ATTACHMENT 1

In order to finalise the Department's assessment, additional information is required including but not limited to the following:

LRGID

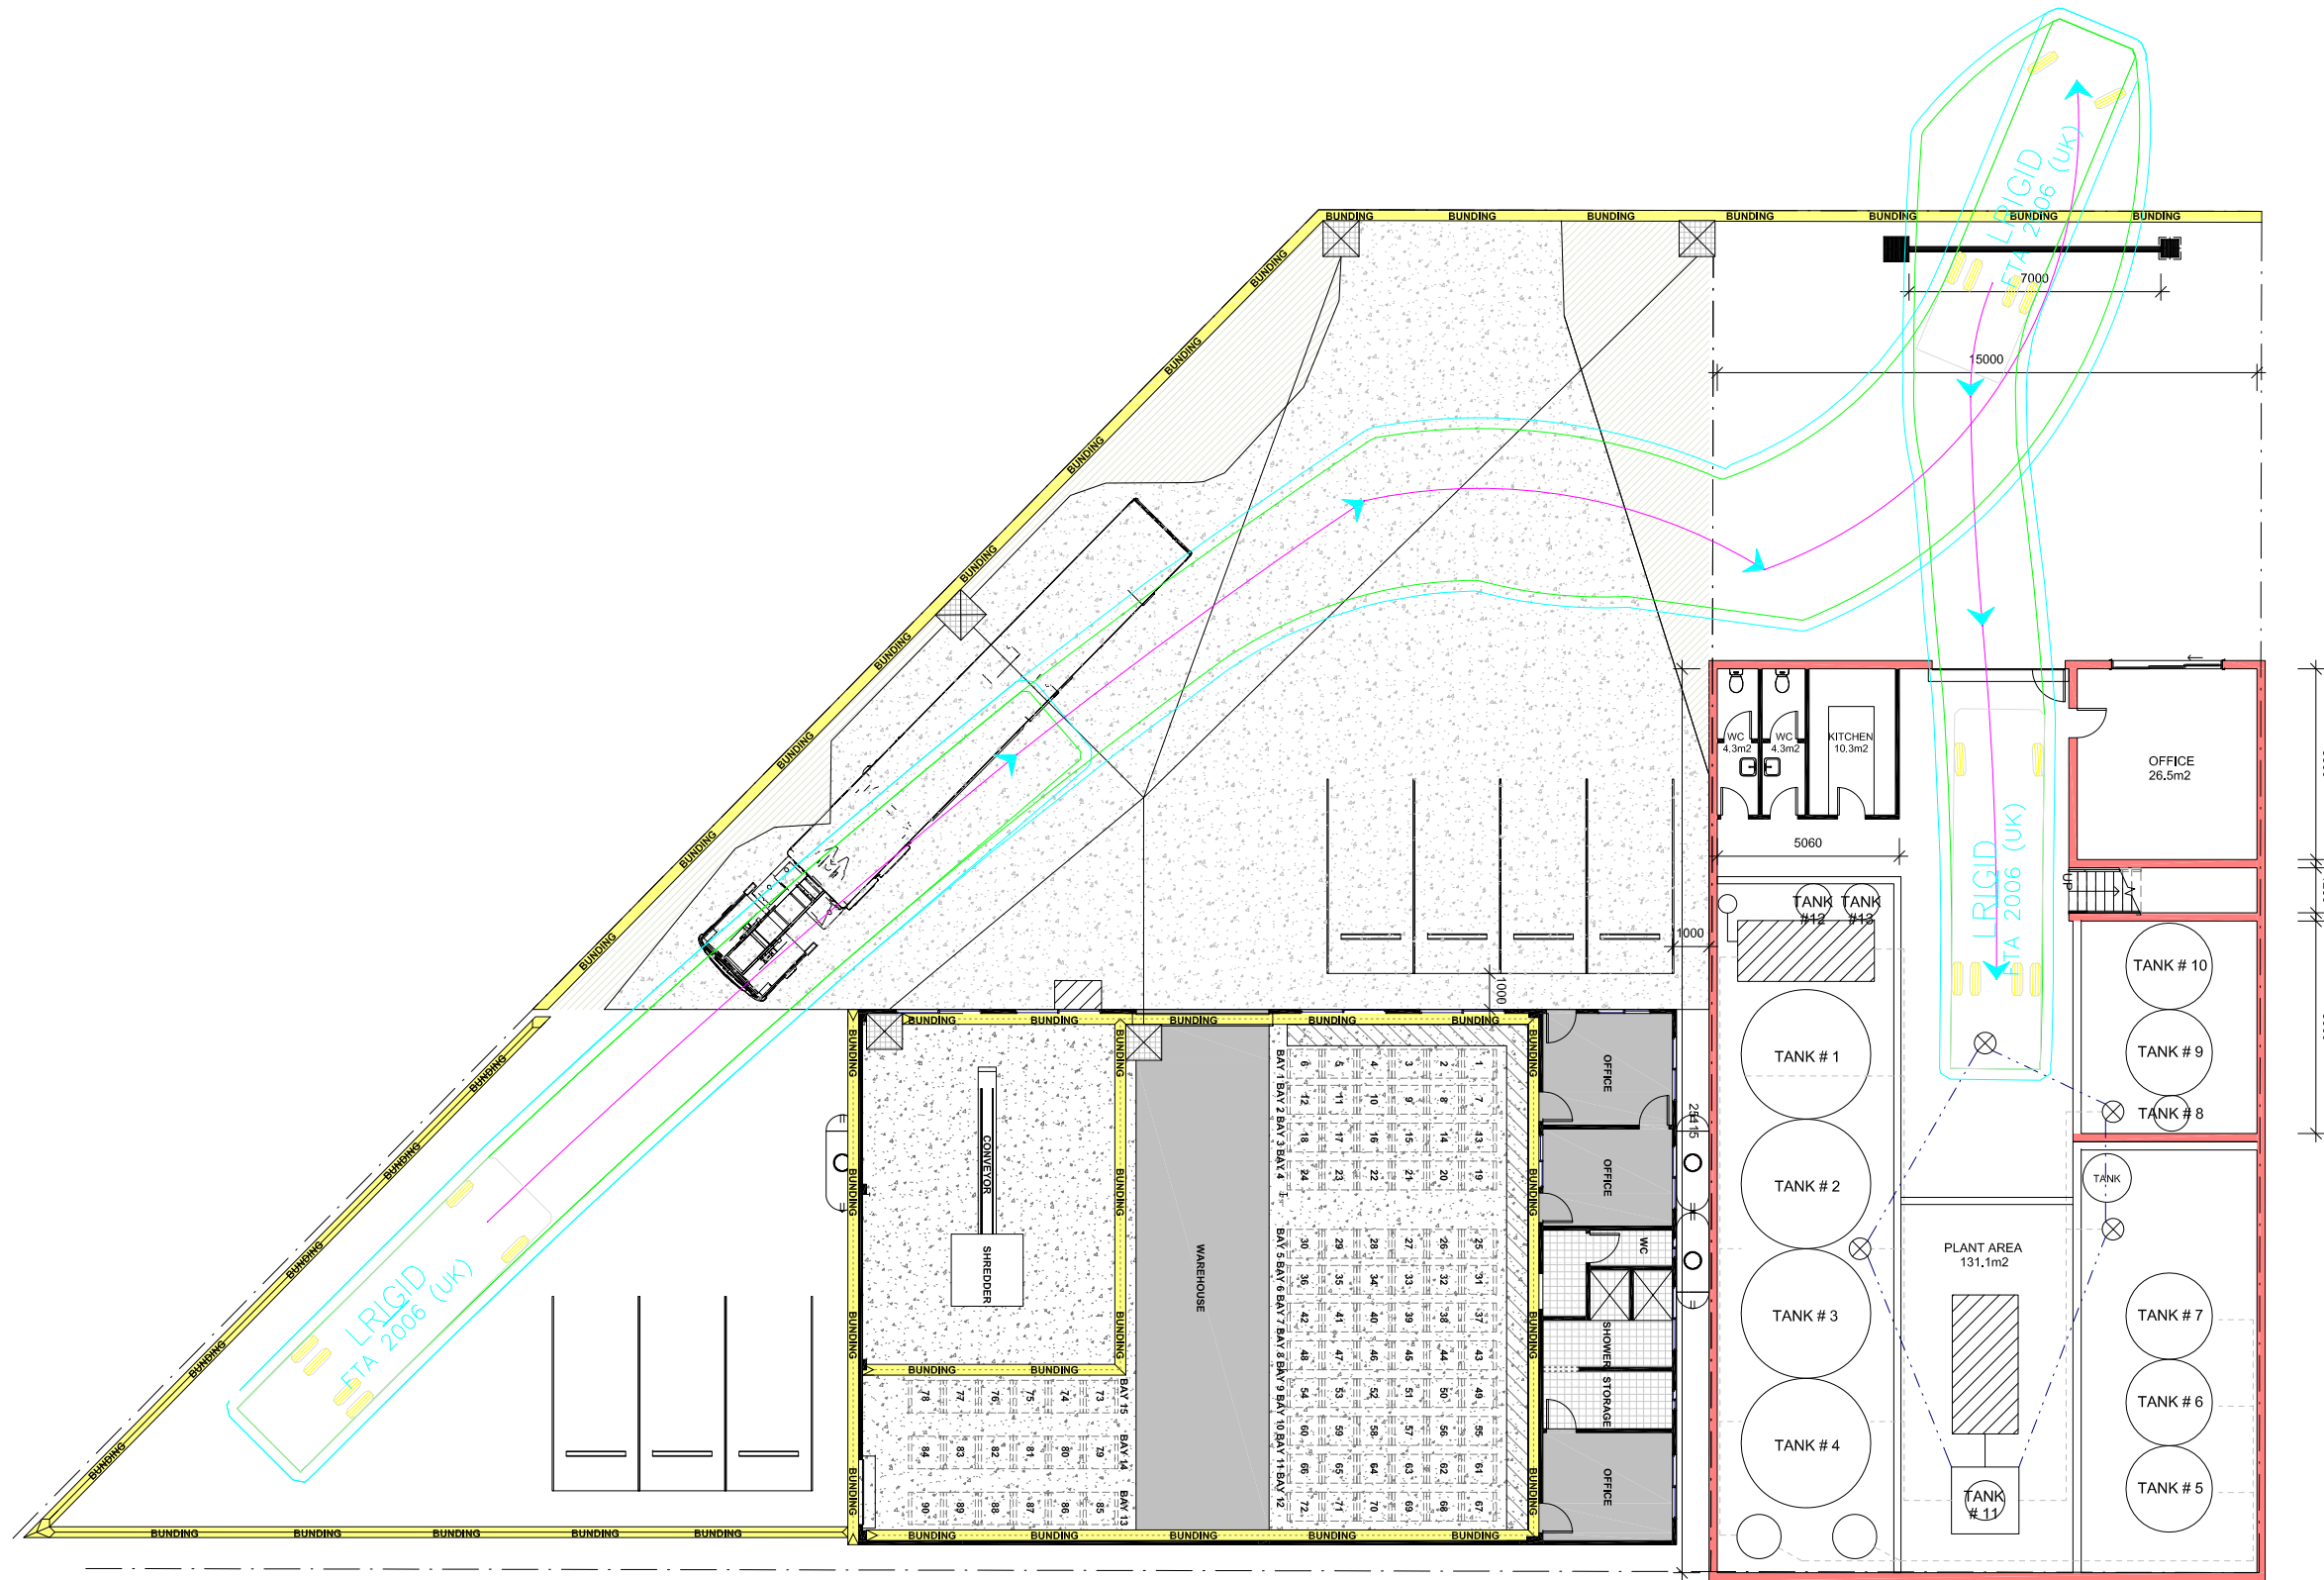
- Previous advice provided by the Department and Council to the Applicant has outlined that the internal swept path movements are not appropriate and need to be updated to demonstrate that turning paths would not encroach onto Council footpath, nature strip or any other infrastructure located on Council land. It is noted that the advice has not been considered in the EIS, it is required that mitigation measures and/or alternatives need to be considered and subsequently updated to meet Council and the Department's requirements.

- The manoeuvring and turning of the vehicle must be completed within the site and must not cause encroachment into nature strip or the footpath. The swept path diagrams demonstrate otherwise with the encroachment into nature strip. As per previous correspondence the Department requested the proponent consult with Council to resolve internal swept path movements satisfactorily. Please provide further evidence of any further consultation with Council regarding the outcome and resolution of these issues.

- The EIS notes that vehicle transporting waste to and from the sites can carry between 2,000 and 30,000 litres (L) of materials and notes that the majority of vehicles accessing the site are owned and operated by the Applicant, however the provided vehicle and truck register (Appendix 8) shows a list of existing truck fleet owned by the Applicant range in carrying capacity from 2,000 to 15,000L. Please clarify how the Applicant intends to transport 30,000 L of waste. It is also noted that vehicles carrying 30,000 L of waste is anticipated to be longer than the 10 metre vehicles assessed in the swept path analysis in the Traffic Impact Assessment (TIA).
